From: Peter Drury (Drew Smith) [REDACTED]
Sent: 21 May 2020 14:04
To: Simon Davis <Simon.Davis@arun.gov.uk>
Subject: RE: P/23/20/DOC - land to north and south of Summer Lane, Pagham

In response to the CEMP comments I can now respond as follows:

Traffic Route Plan

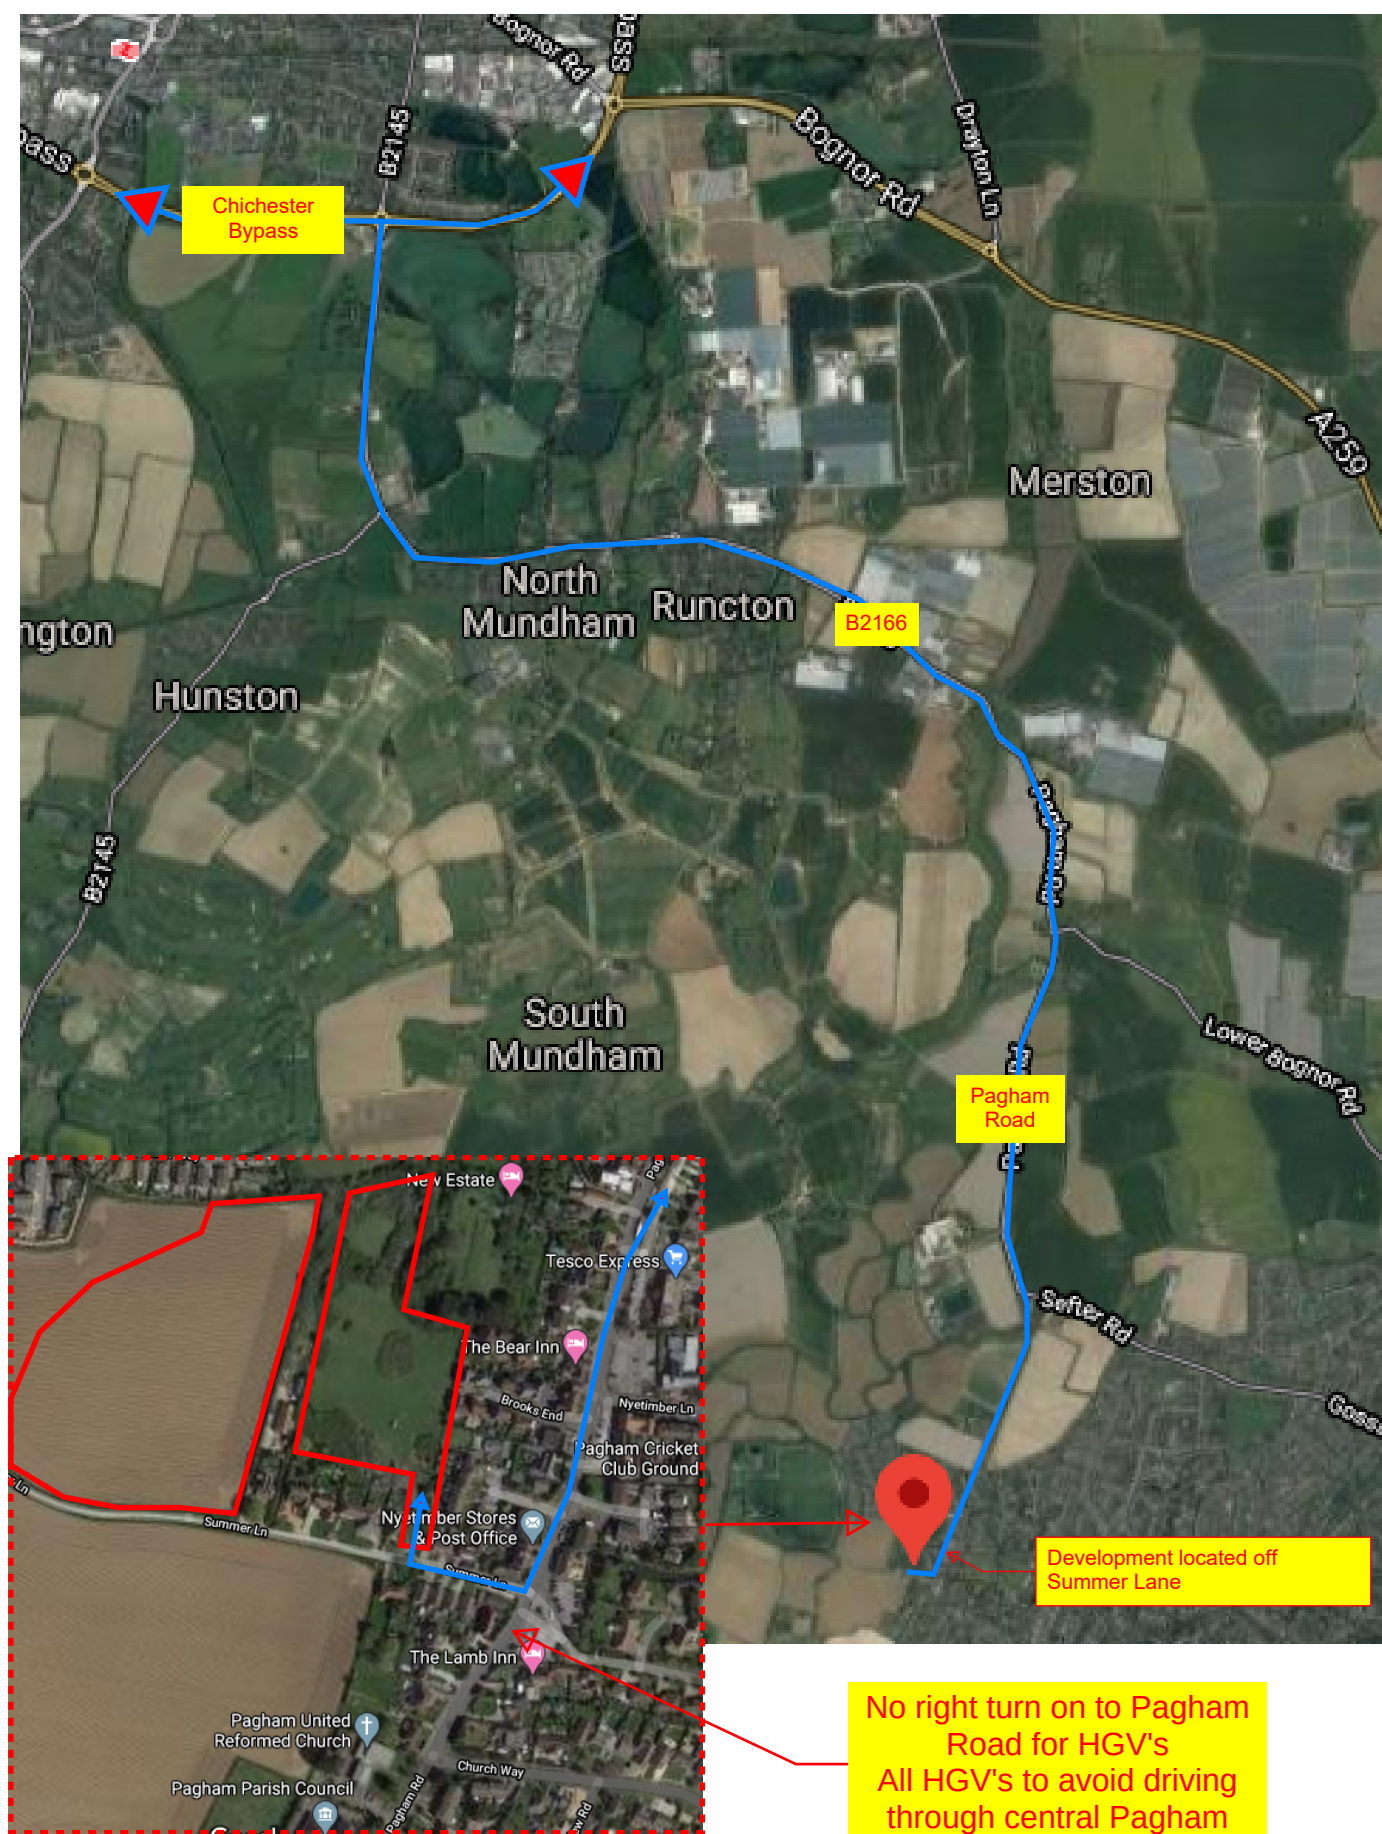
3. Vehicle routing: The CEMP includes a traffic routing plan which has been updated to show the traffic routing from the development to Chichester Bypass. A clear note has been added to the revised plan to state that HGV's must not turn right on to Pagham Road and they should avoid central Pagham.
